September 29, 2008

Thank you for the opportunity to comment on the Star View Short Plat (SP-08-00039). In order to meet the requirements set forth by Kittitas County Public Health's Environmental Health Division and Kittitas County Code Chapter 13, the following items must be submitted:

STAR VIEW SHORT PLAT
KITTITAS COUNTY SHORT PLAT NO. 08-XX
PORTION OF THE SW 1/4, SEC. 09, T.20N., R.15E., W.M.
KITTITAS COUNTY, WASHINGTON

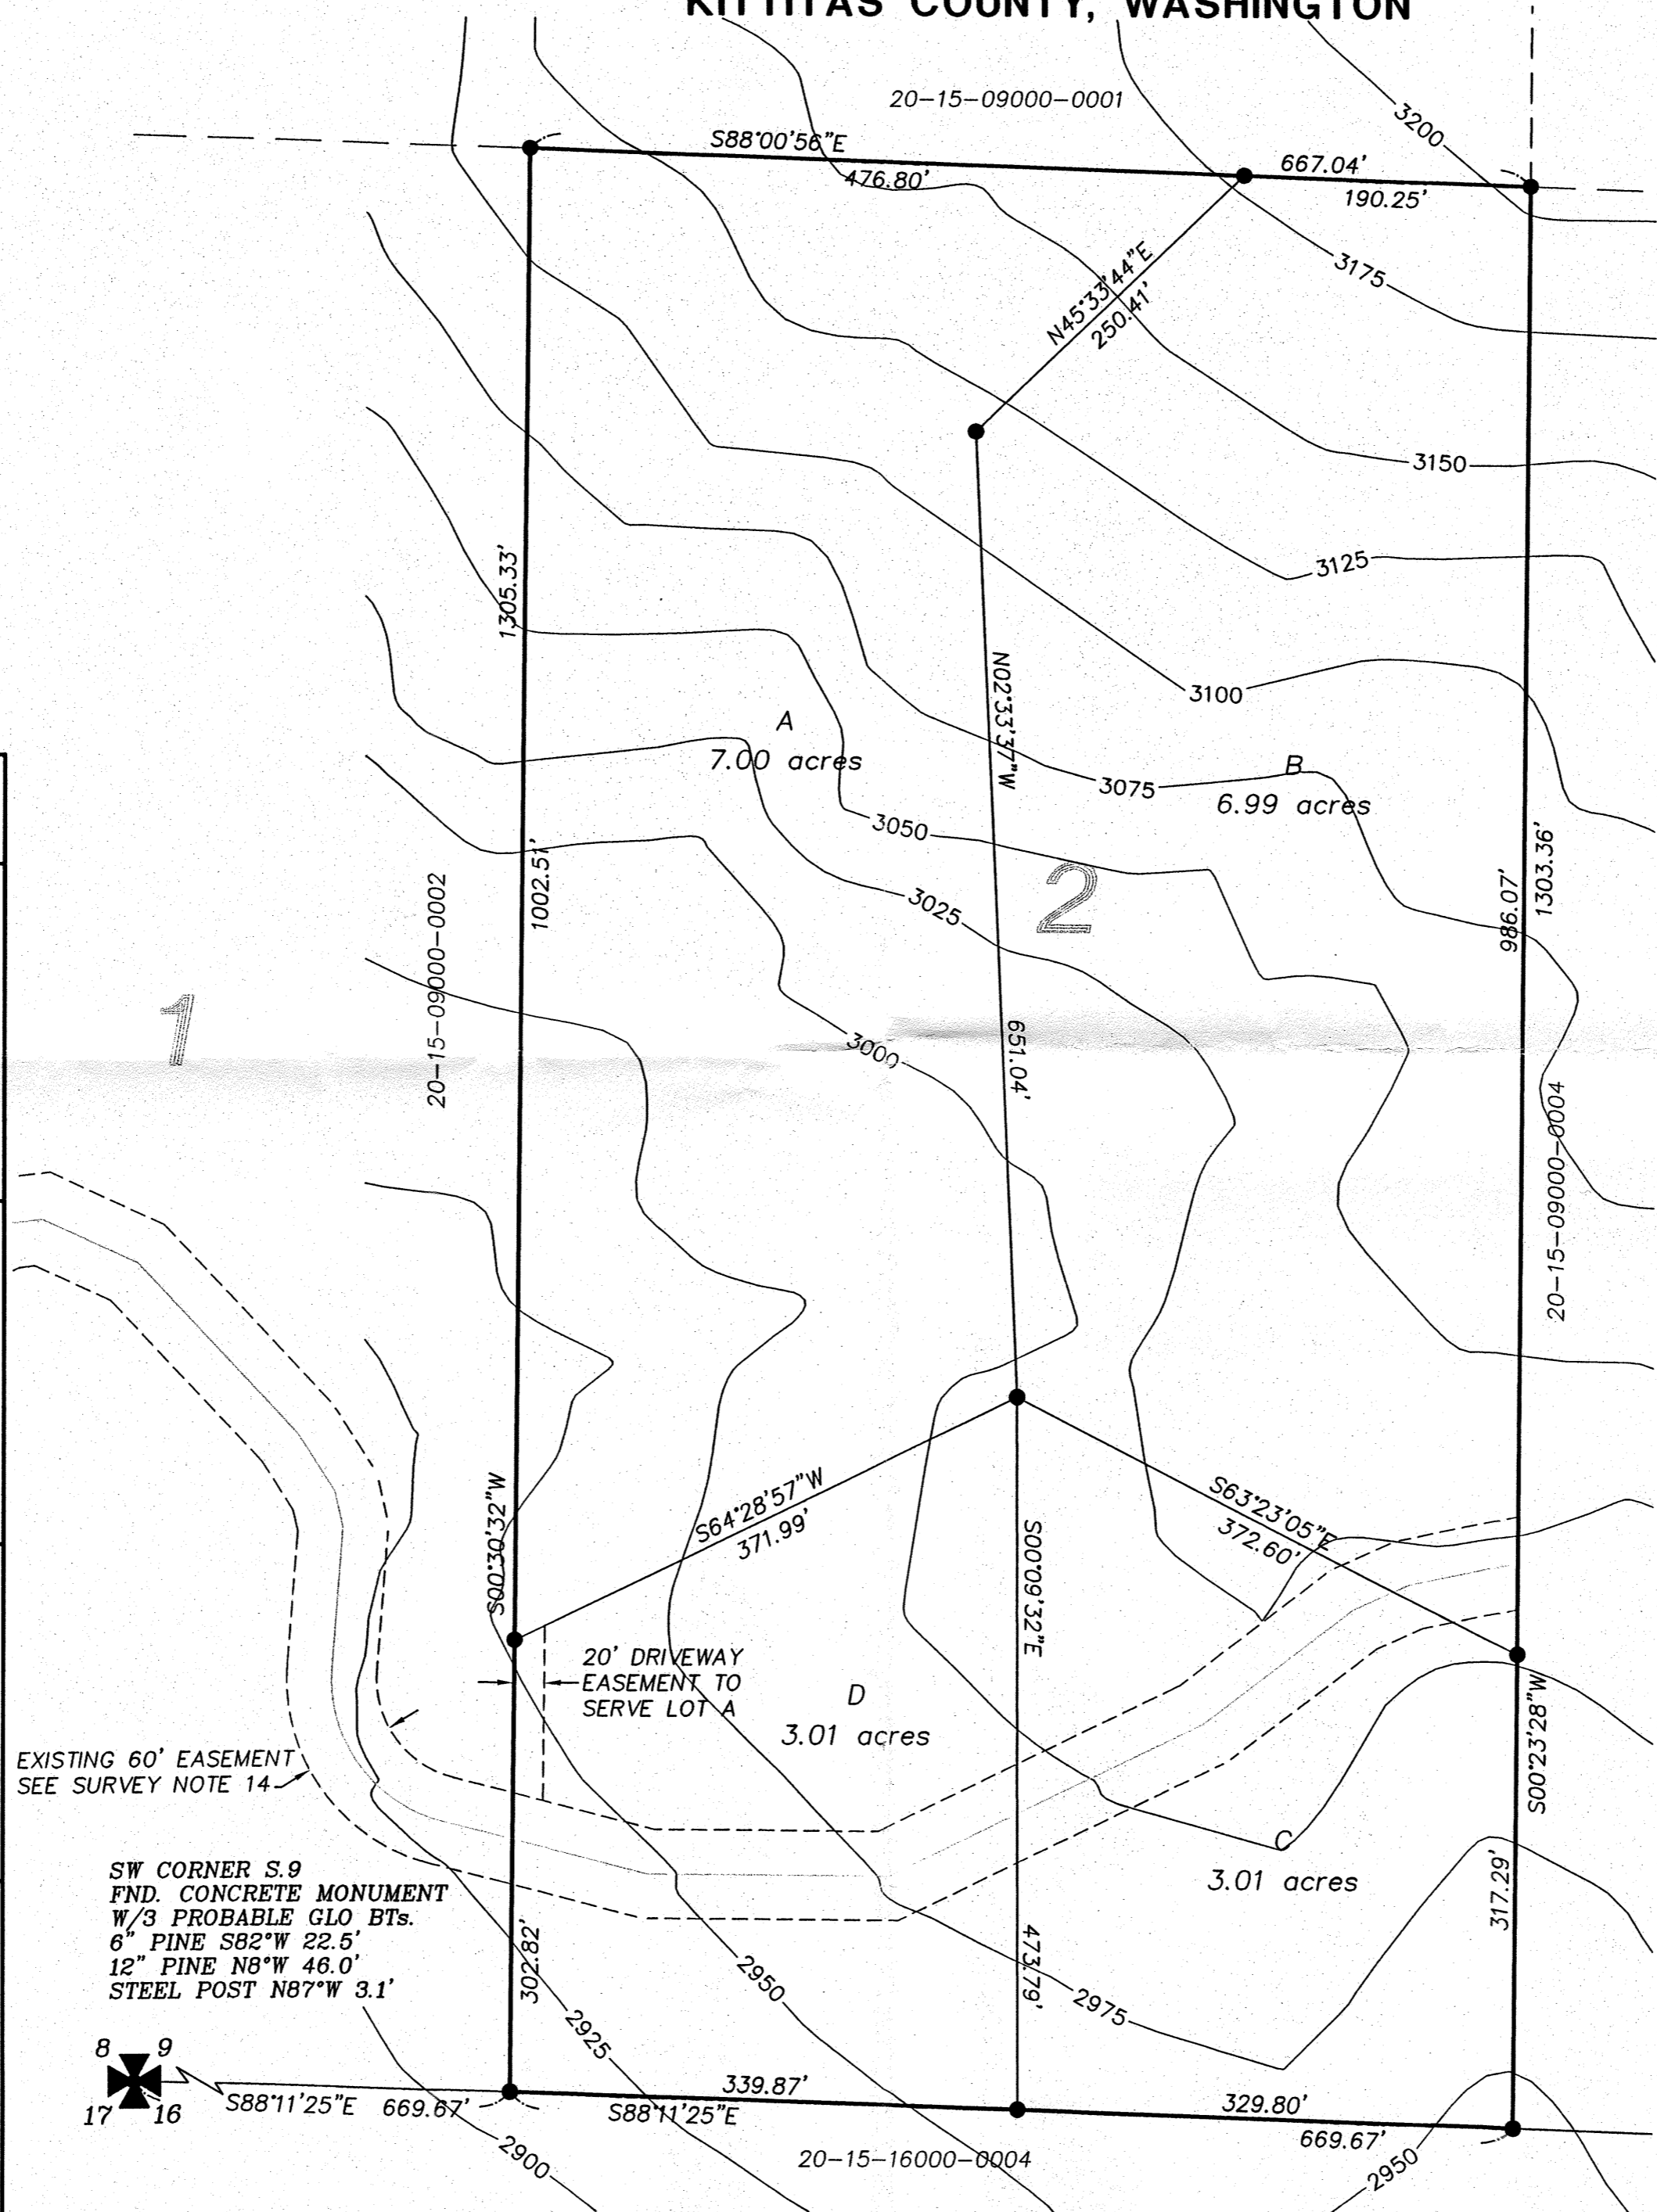
- *The following plat notes shall be included on the final mylar:*
 1. "The approval of this division of land includes no guarantee that there is a legal right to withdraw groundwater within the land division. The approval of this division of land provides no guarantee that use of water under the ground water exemption (RCW 90.44.050) for this plat or any portion thereof will not be subject to curtailment by the Department of Ecology or a court of law."

2. "The Star View Preliminary Plat No. SP-08-00039 currently has 5000 gallons of water per day for all domestic uses from the domestic well use exemption. According to WAC 173-539A each lot of this plat is allowed no more than 1250 gallons per day per lot".

Note: if distribution of the available water between parcels is different than listed above, specify the quantity of water in gallons per day by parcel on the final mylar.
